Richard Davies  
46A Gloucester Street,  
The Rocks, NSW

Your Reference: 35-75 Harrington Street, The Rocks (SSD-32766230)

Correspondence Date: 10 December 2023

Subject: Response to Notice of Exhibition SSD-32766230

Roof Form - FT12

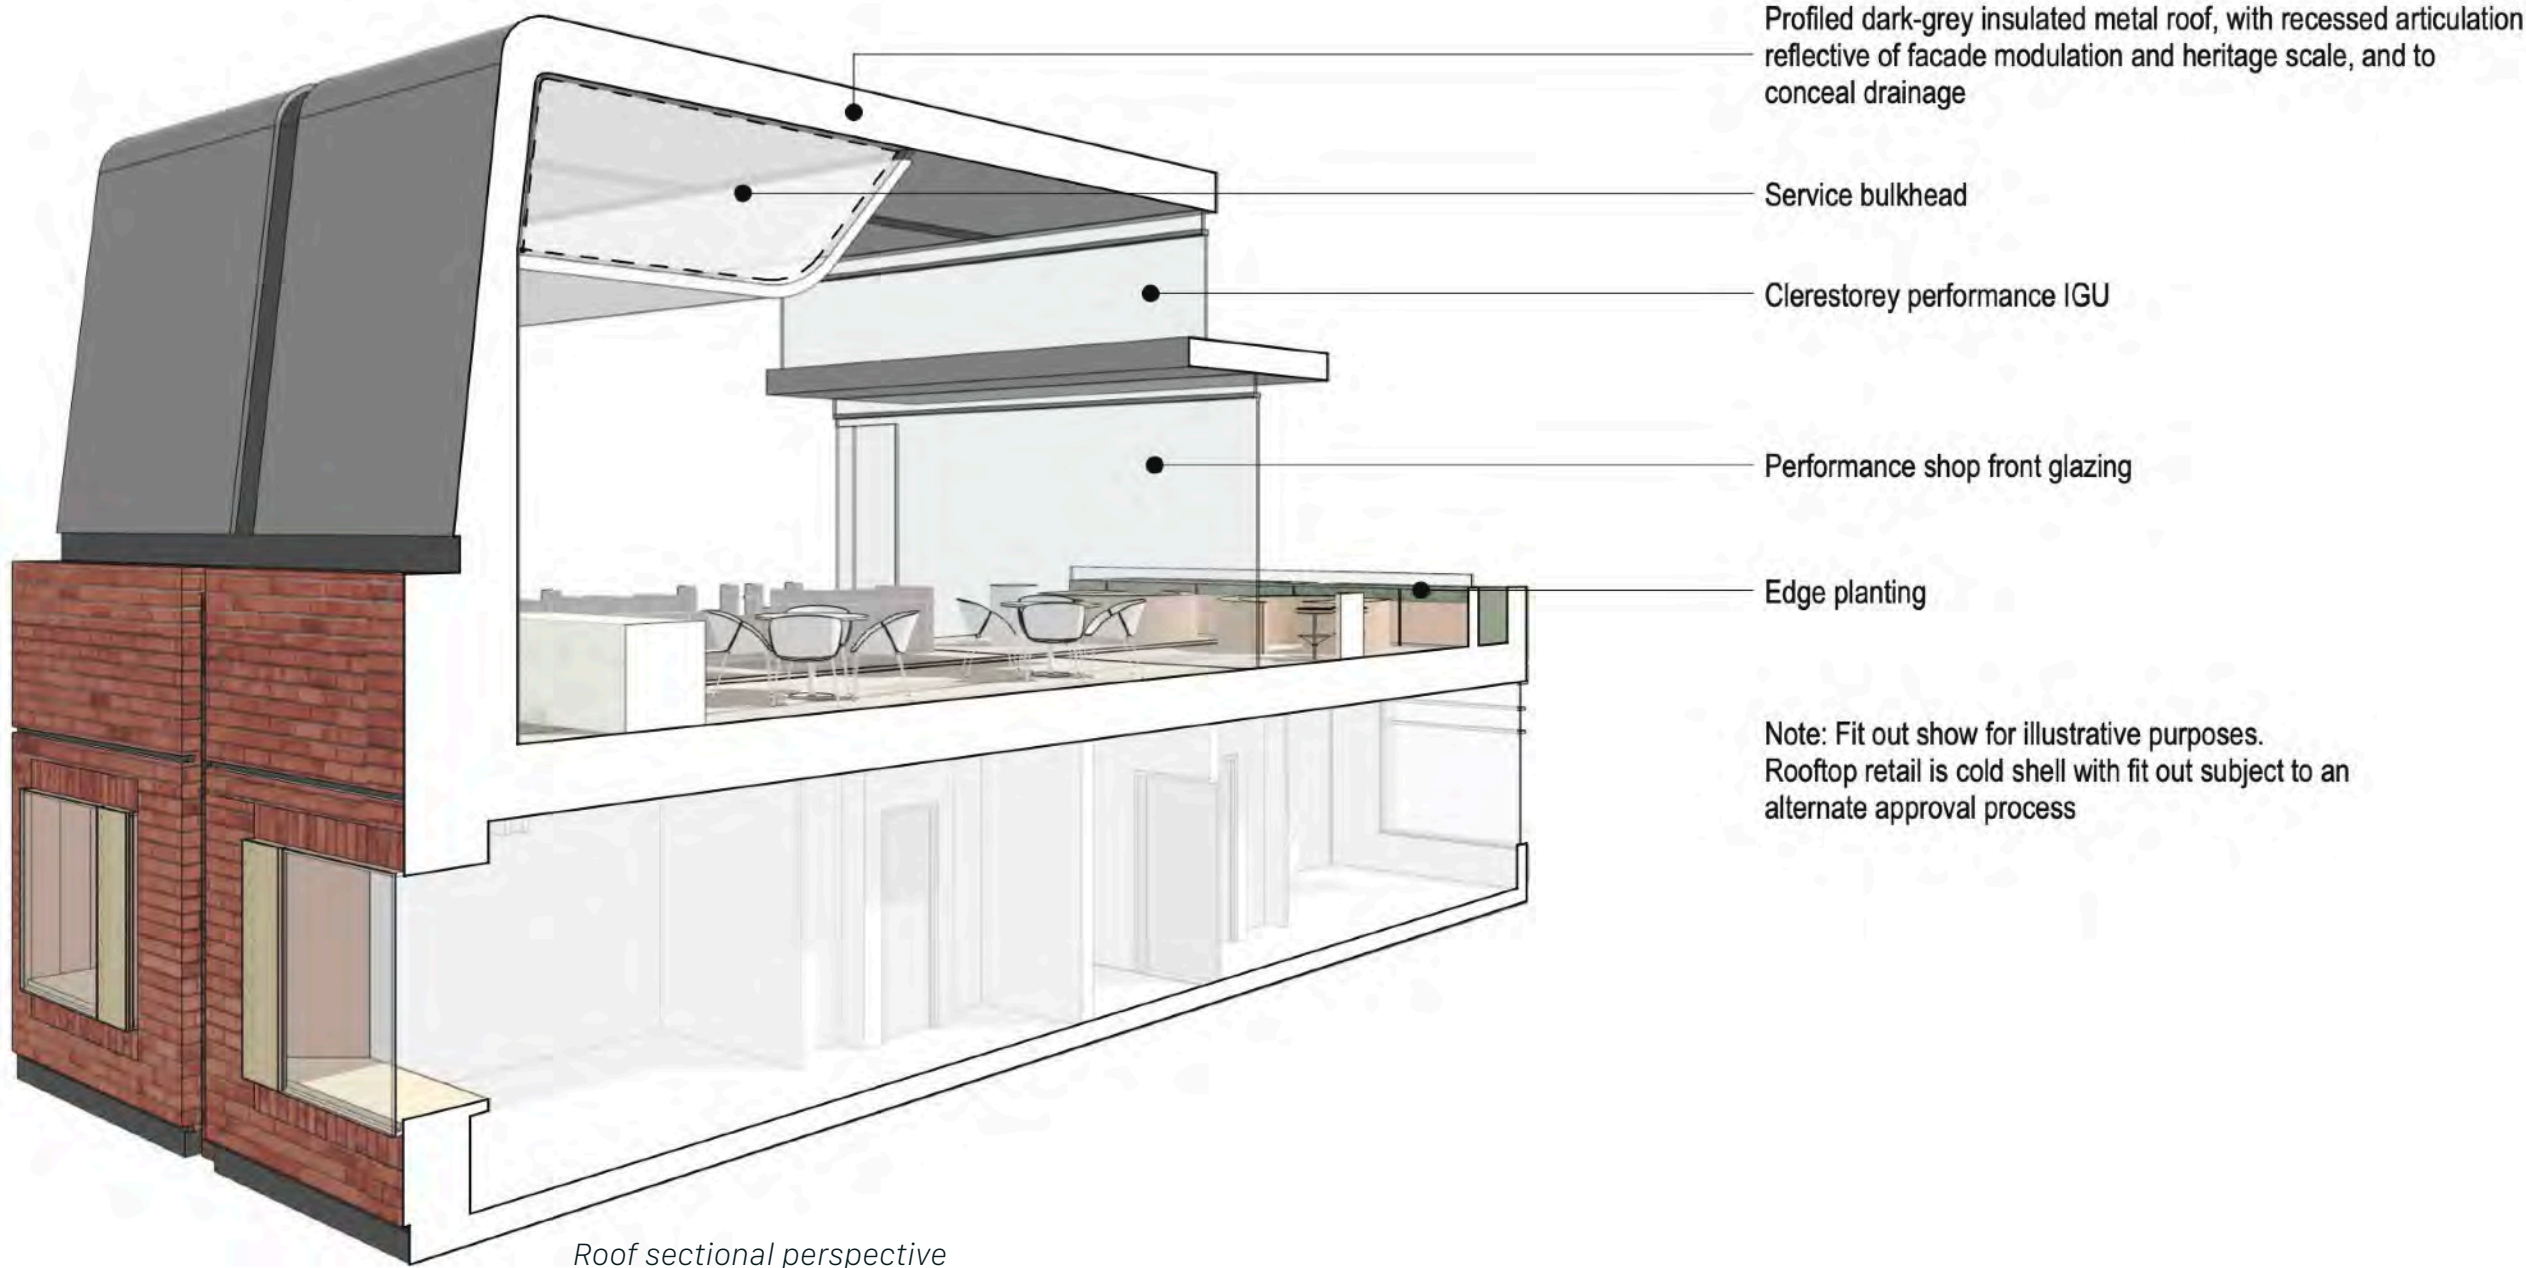
19. The clarity of the applicants ignoring of the southwestern quadrant is clearly exemplified in the diagram contain in Appendix H – Architectural Design Report Part 2 Materials and Façade Roof Form – FT12, which clearly ignores the presence of the Gloucester Terraces in that quadrant, as they are not even present in the diagram.
